RAINAGE AND TRANSPORTATION INFORMATION SHEET

Project Title: Vermeer Sales Southwest City Drainage #: _____

VERMEER SALES SOUTHWEST SITE IMPROVEMENTS

**RE: GRADING AND DRAINAGE CERTIFICATION FOR
PERMANENT CERTIFICATE OF OCCUPANCY
VERMEER SALES, 9005 WASHINGTON ST. NE**

<b>VERMEER SALES SW</b>	DRAWN BY DY
	<b>WASHINGTON ST NE</b>	DATE 2/23/12
	<b>GRADING AND DRAINAGE PLAN</b>	2012006-GRB
	<b>TIERRA WEST, LLC</b> 5571 MIDWAY PARK PLACE NE ALBUQUERQUE, NM 87109 (505) 858-3100 www.tierrawestllc.com	SHEET # <b>C1</b>
		JOB # 2012006

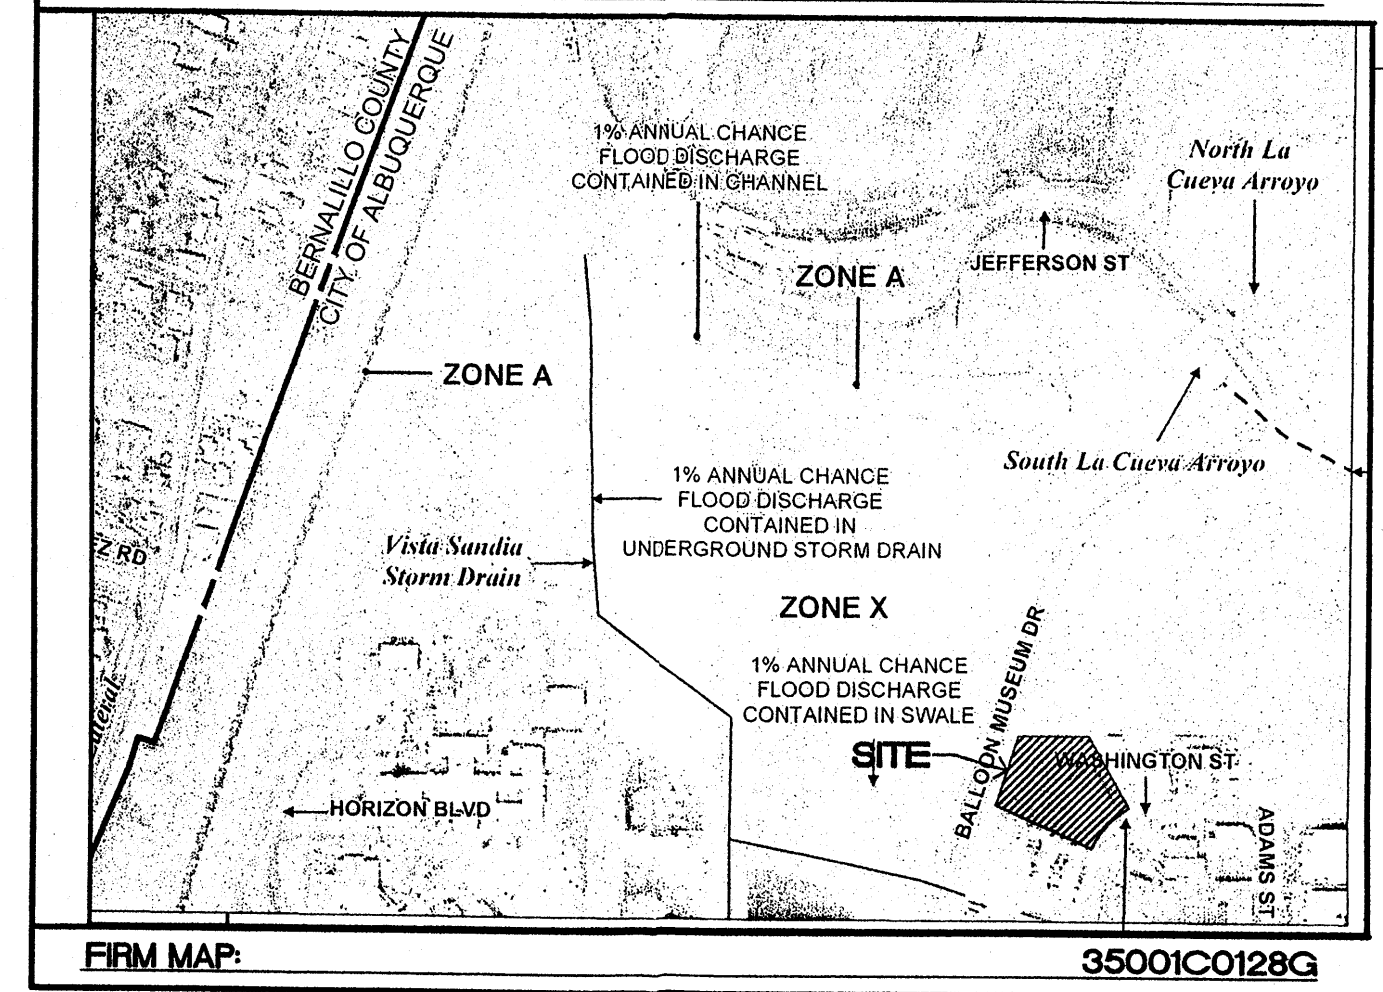
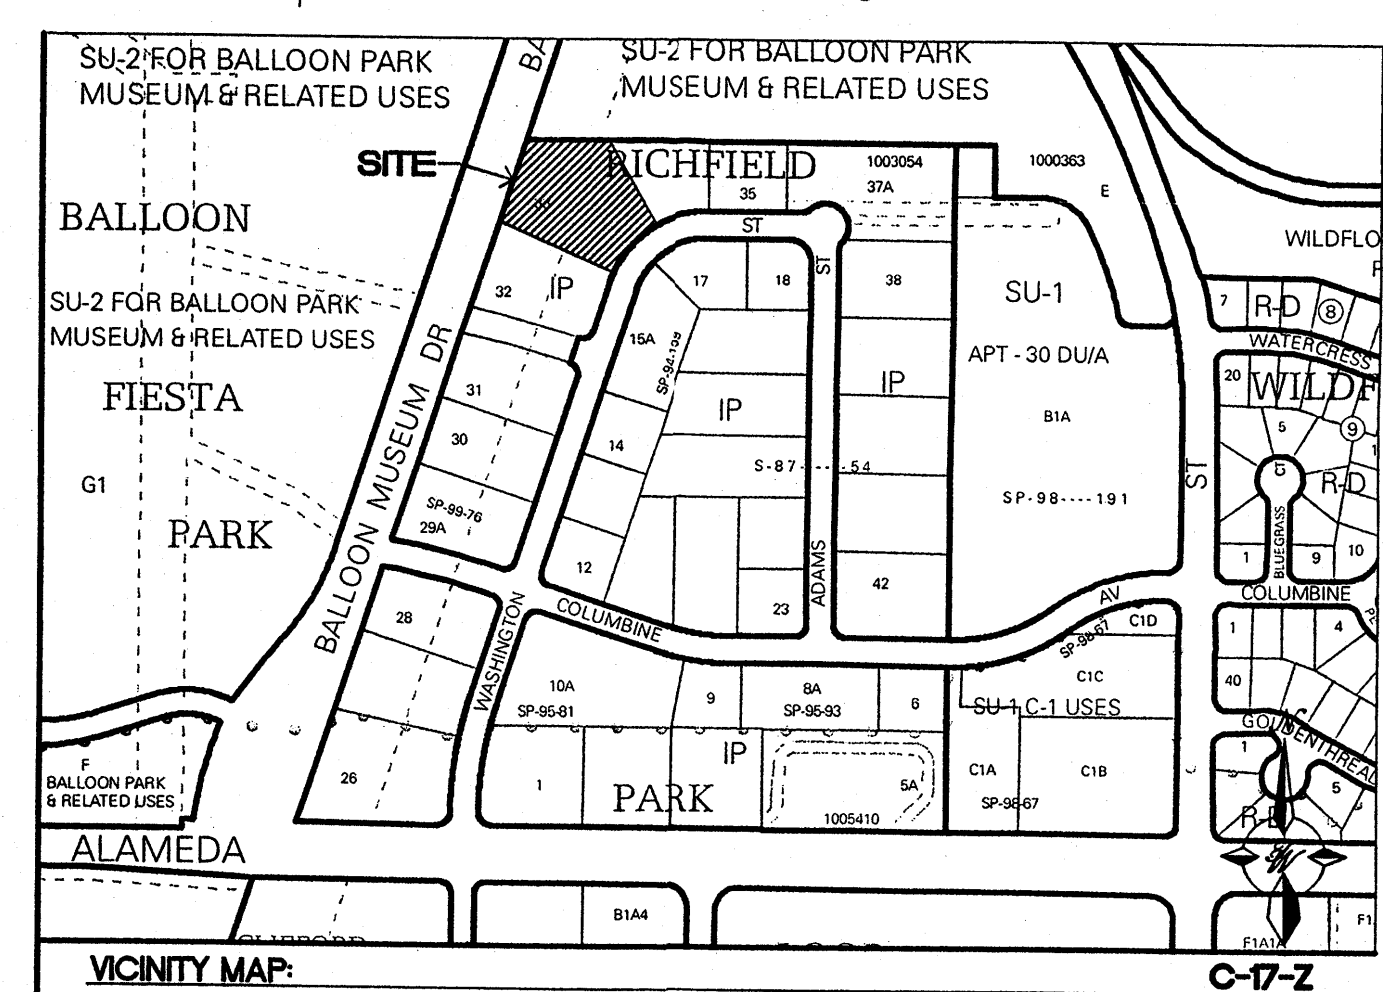
Jon,
 Finally got to clear some time.
 Seems there is a wall or fence along the western boundary that is not shown on the site plan. There is a large shadow on the aerial photograph.
 I already spoke to the architect on this one.
 You should submit a conceptual plan that addresses how the site will deal with the wash water and a brief narrative on site drainage (it is a drainage submittal). The City and AMAFCA don't want oil and sediment laden water entering the storm drain system. I mentioned to the architect about this and she mentioned an oil/water and a separate sediment separator that drains to the SAS.
